TSA Management
Tweed Valley Hospital
771 Cudgen Road
Cudgen NSW 4895

25 February 2020

Re: Response to submissions from the NSW Department of Planning, Industry and Environment (DPIE) and the Biodiversity and Conservation Division (BCD) of the Environment, Energy and Science Group in the DPIE.

Zonal Plan

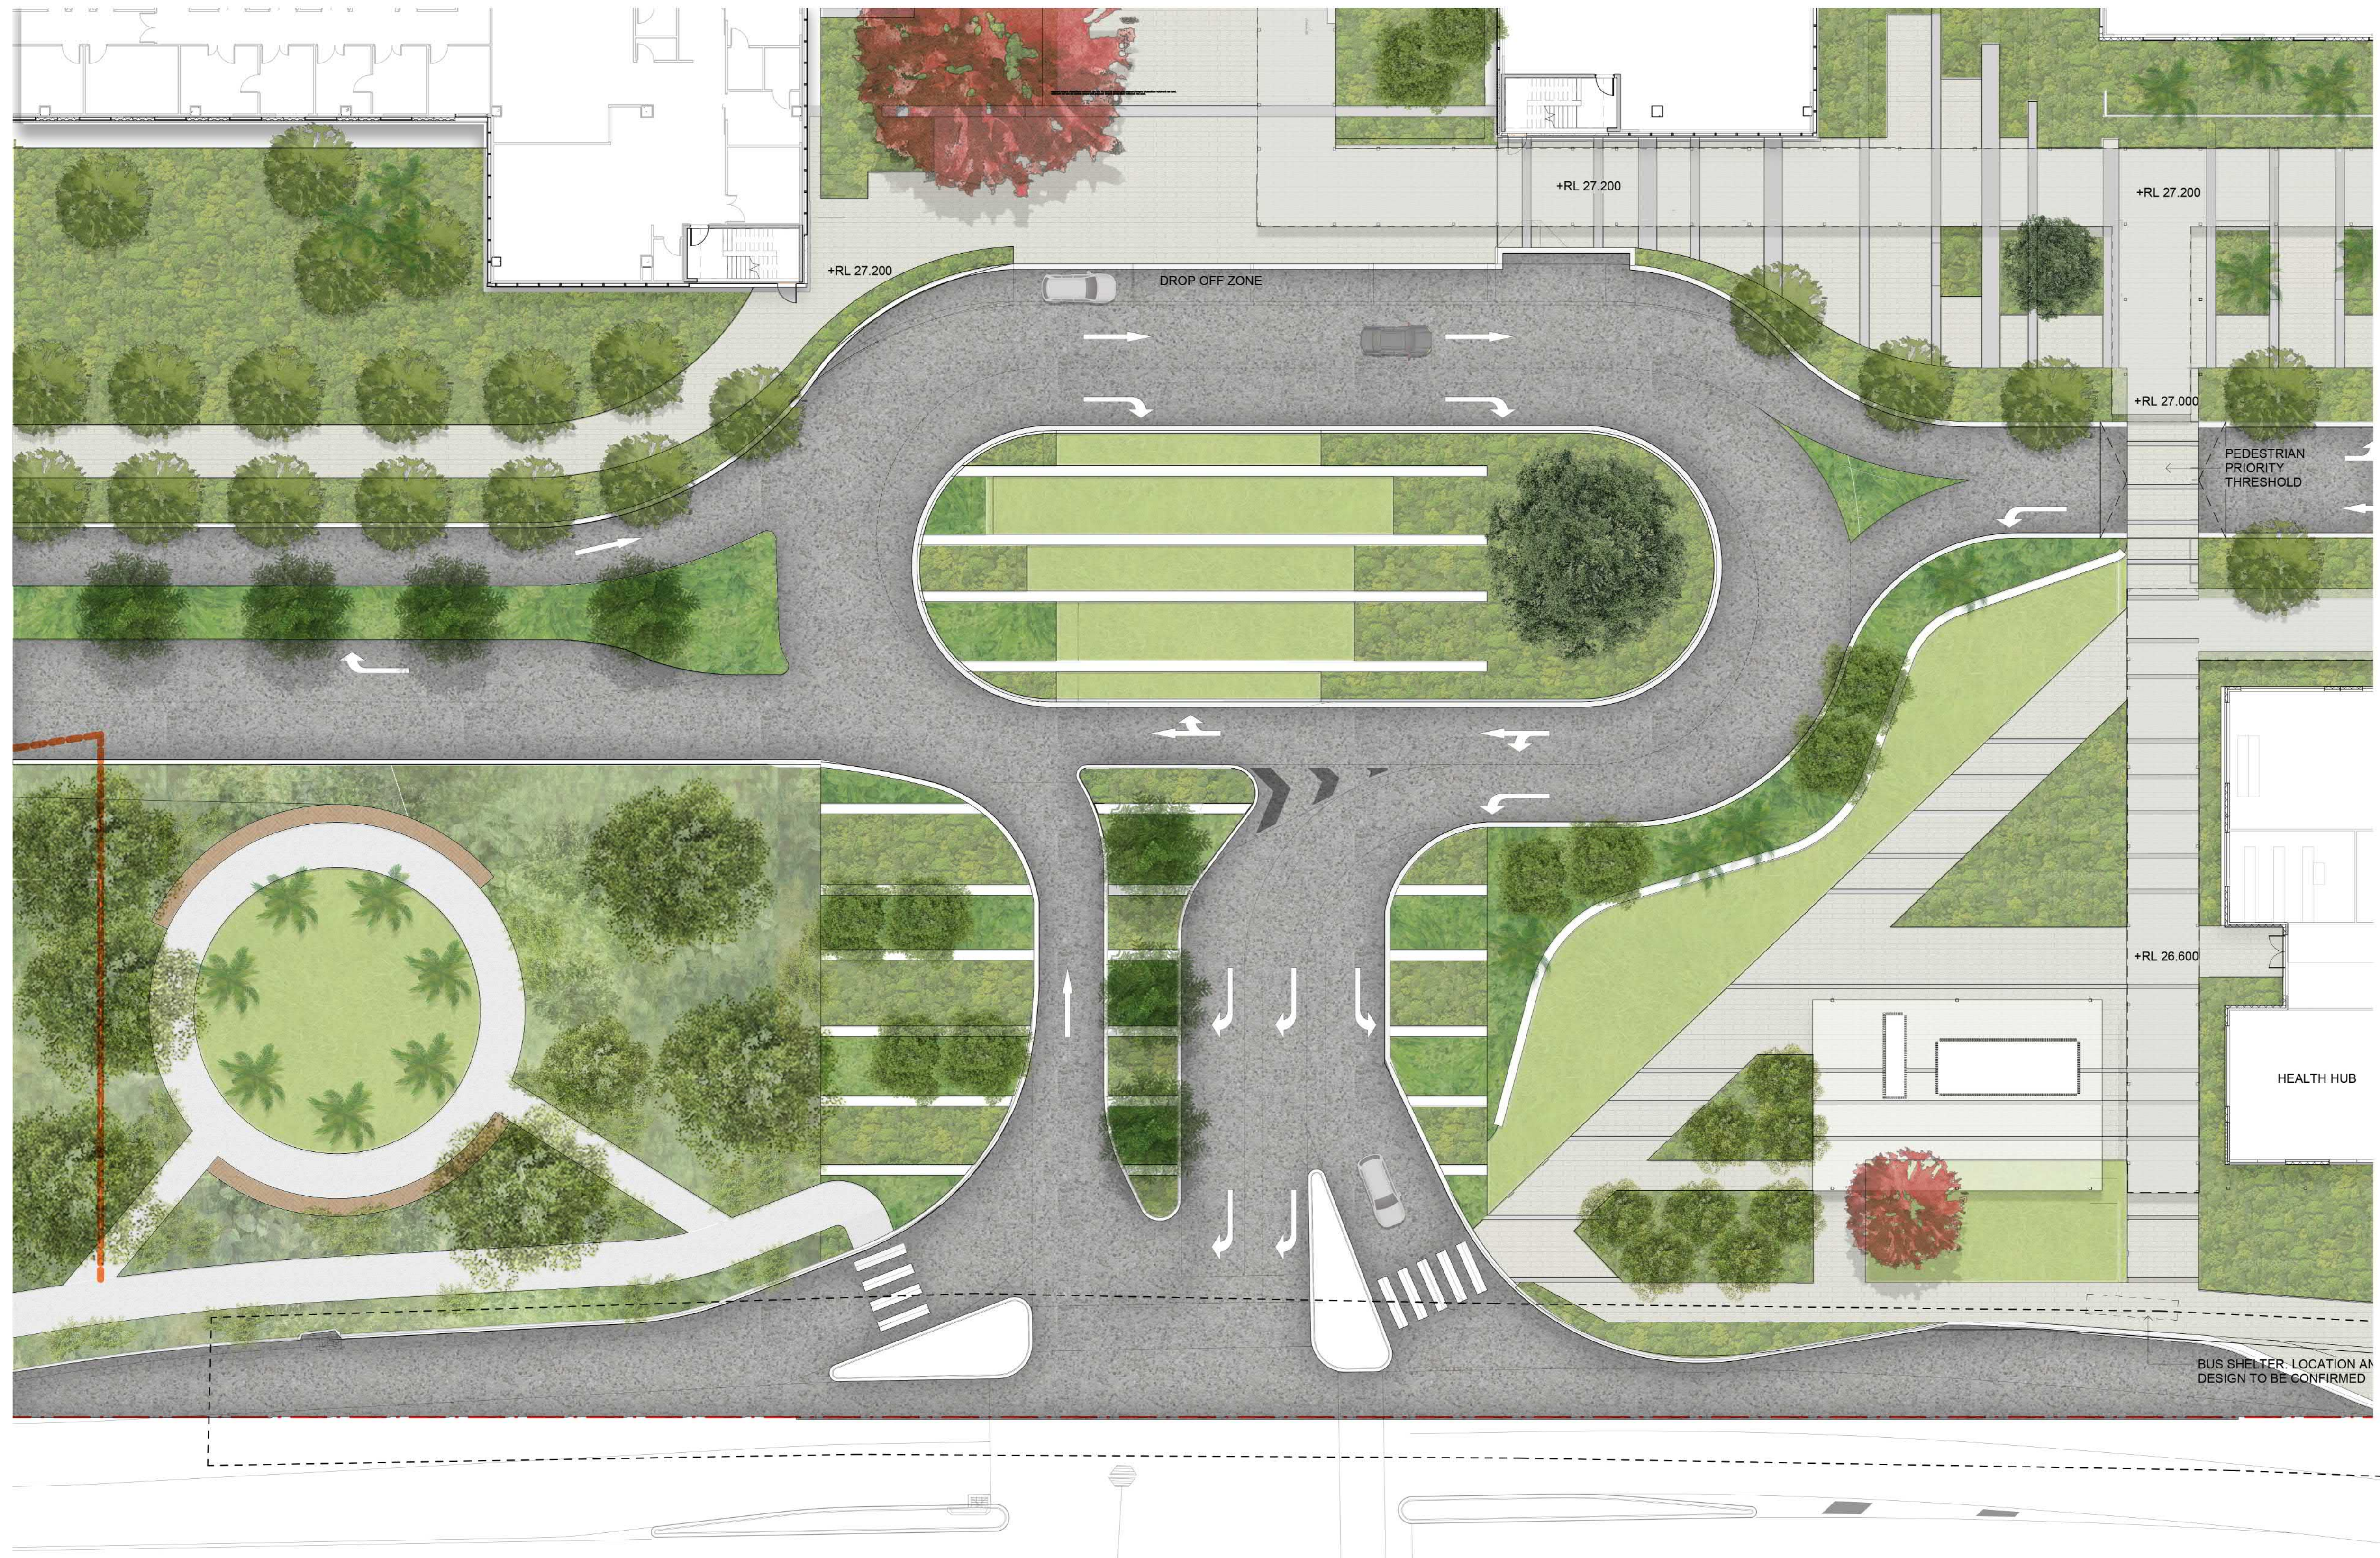
Consideration be given to planting koala food trees in the south west corner (Area 7 in the Landscape Zonal Plan (LZP)) and lawn area (labelled 10 in the LZP) along the northern boundary adjacent to the retained vegetation.	See response above.
Aviation operations		
Attachment 2 1. Aviation Report The submitted Aviation assessment must be updated to consider the impacts of the	6 a. Revise the Avipro report to consider other potential locations for flying-fox camps, as identified in the Tweed and through discussions with Tweed Shire Council and any wildlife carer organisations	<p>Stage 2 BMP Section 3.8.3 to be updated to align with any revisions of the AviPro report. See below;</p> <p><i>‘The siting of the HLS and primary considerations in HLS approach and departure path selection</i></p>
